BARBARICK RECYCLING AND REFUSE TRANSFER STATION

GRADING AND EROSION CONTROL PLAN DECEMBER 2023

BARBARICK WASTE TRANSFER STATION
EL PASO COUNTY, COLORADO
GRADING AND EROSION CONTROL
COVER SHEET

BARBARICK WASTE TRANSFER STATION
EL PASO COUNTY, COLORADO
GRADING AND EROSION CONTROL
INTERIM GEC PLAN

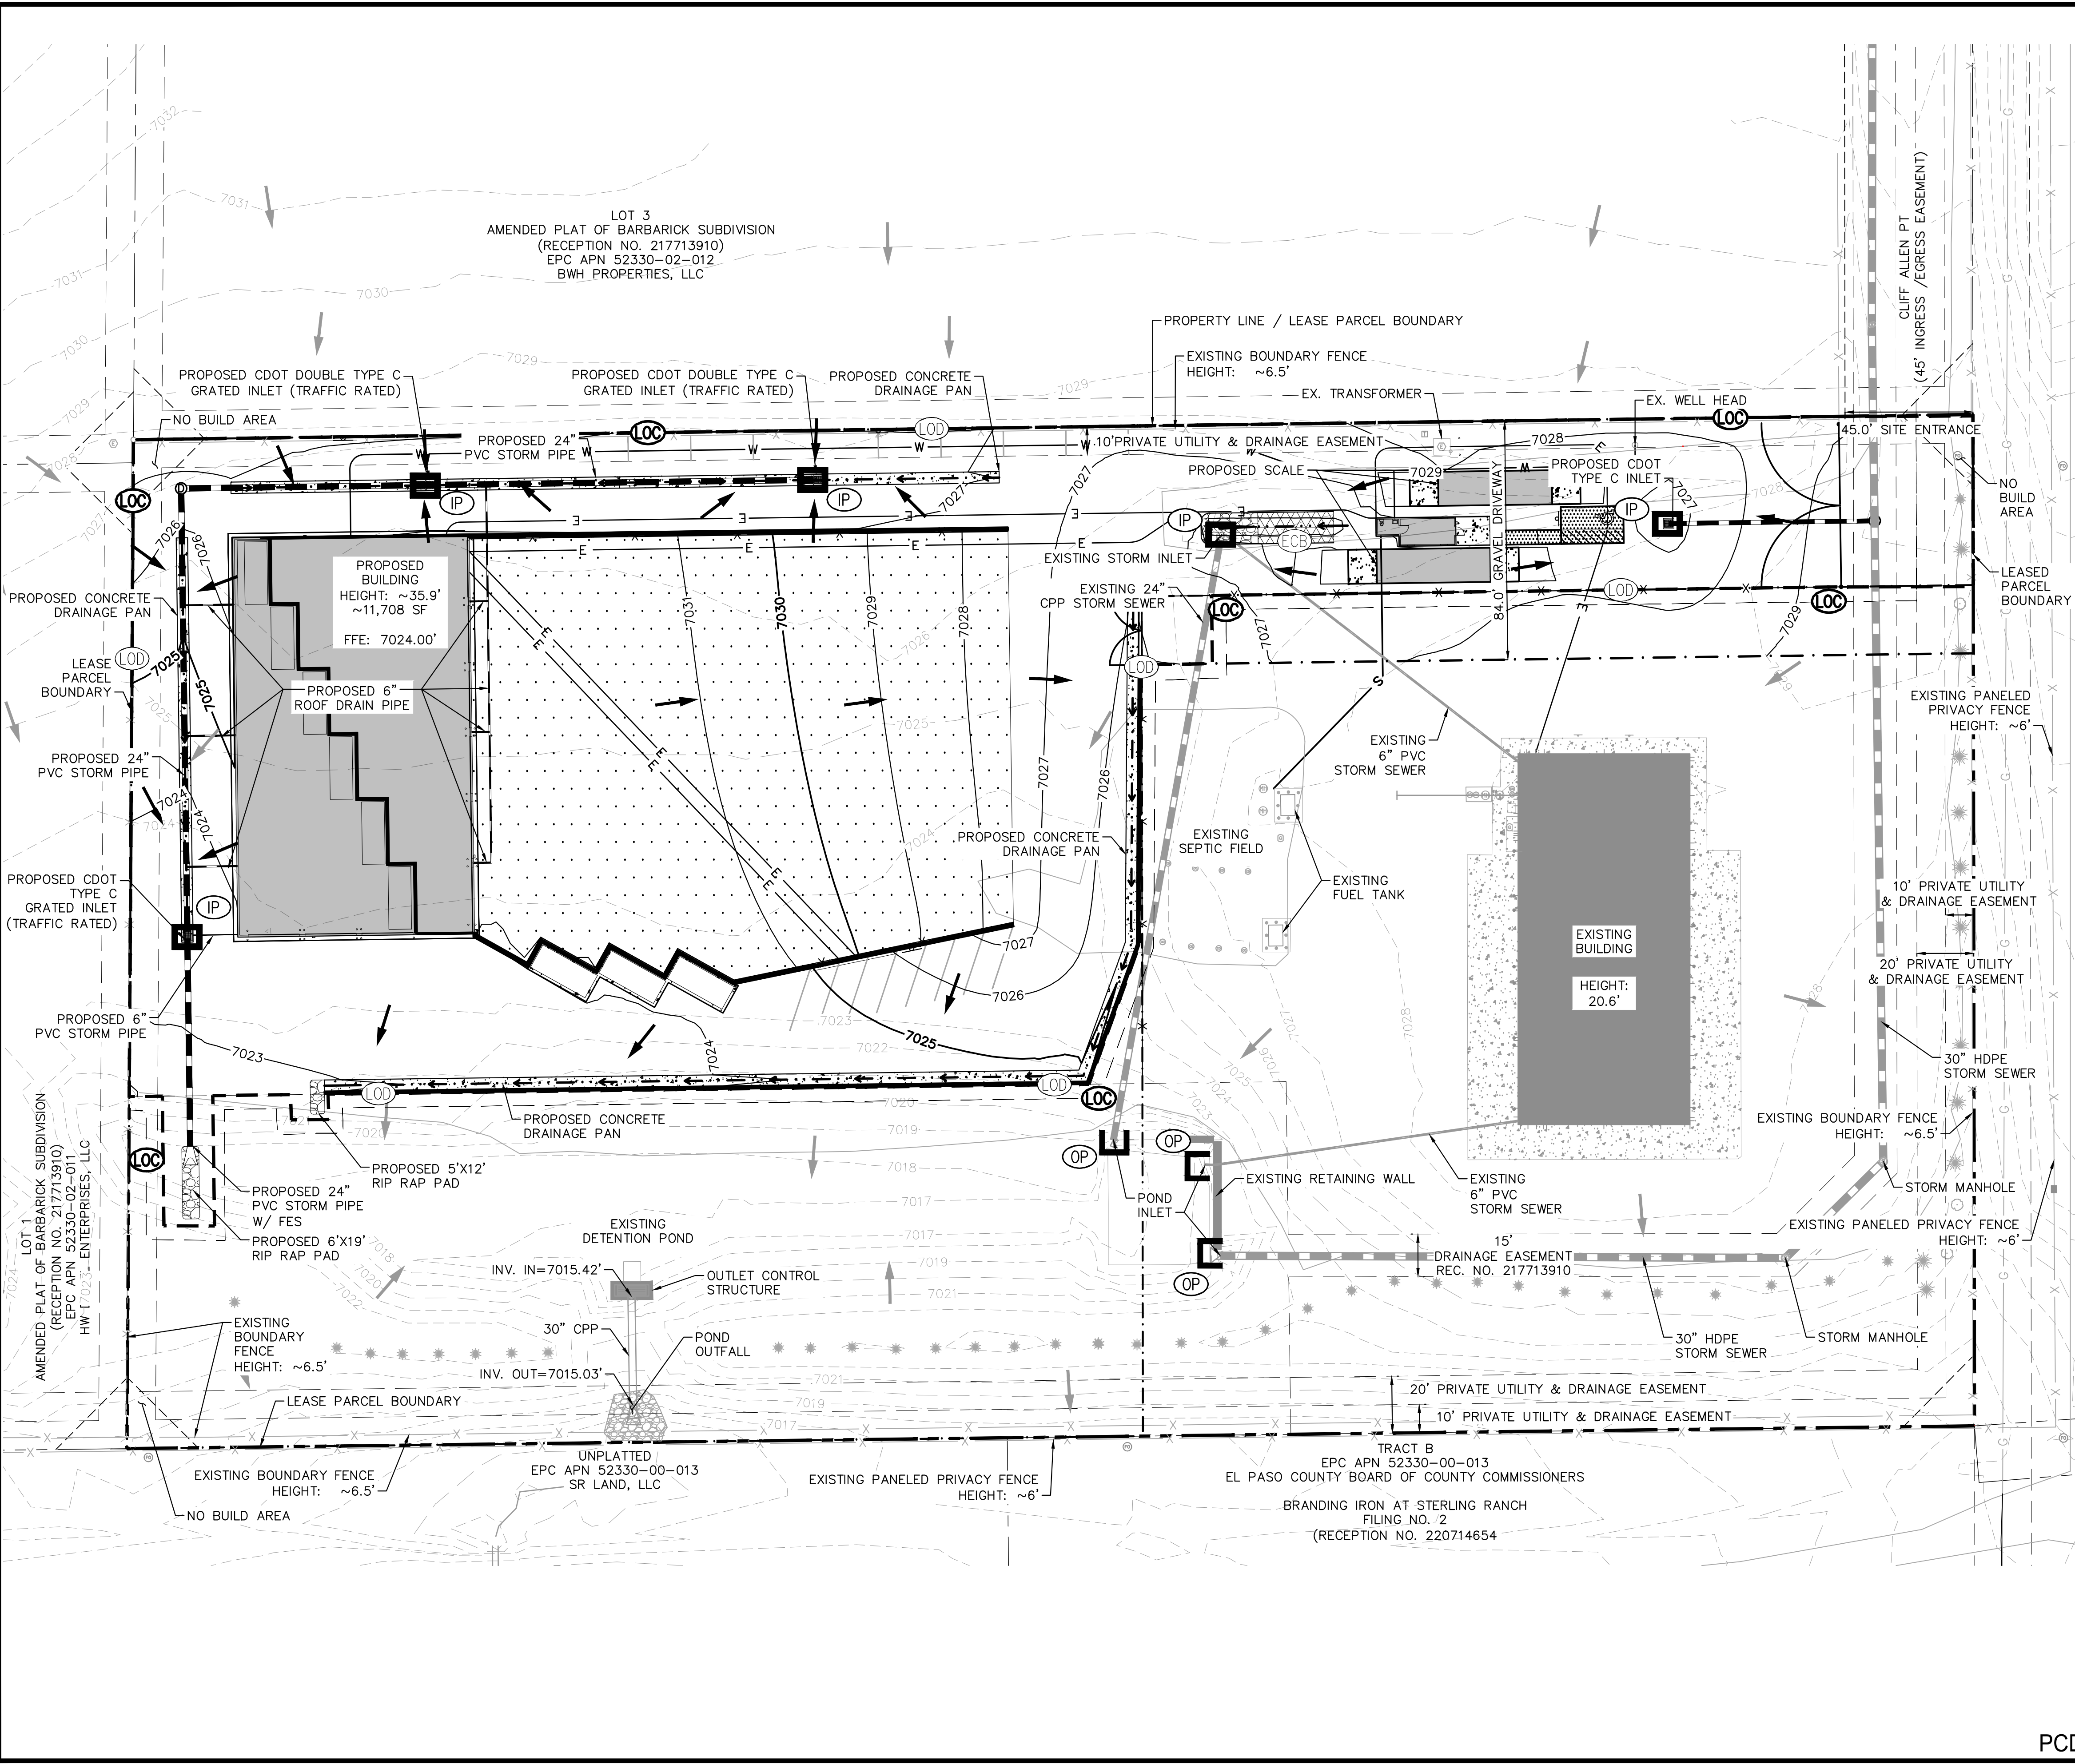
Provide size of riprap and depth of riprap pads. And consider need for bedding and/or geotextile fabric beneath riprap.
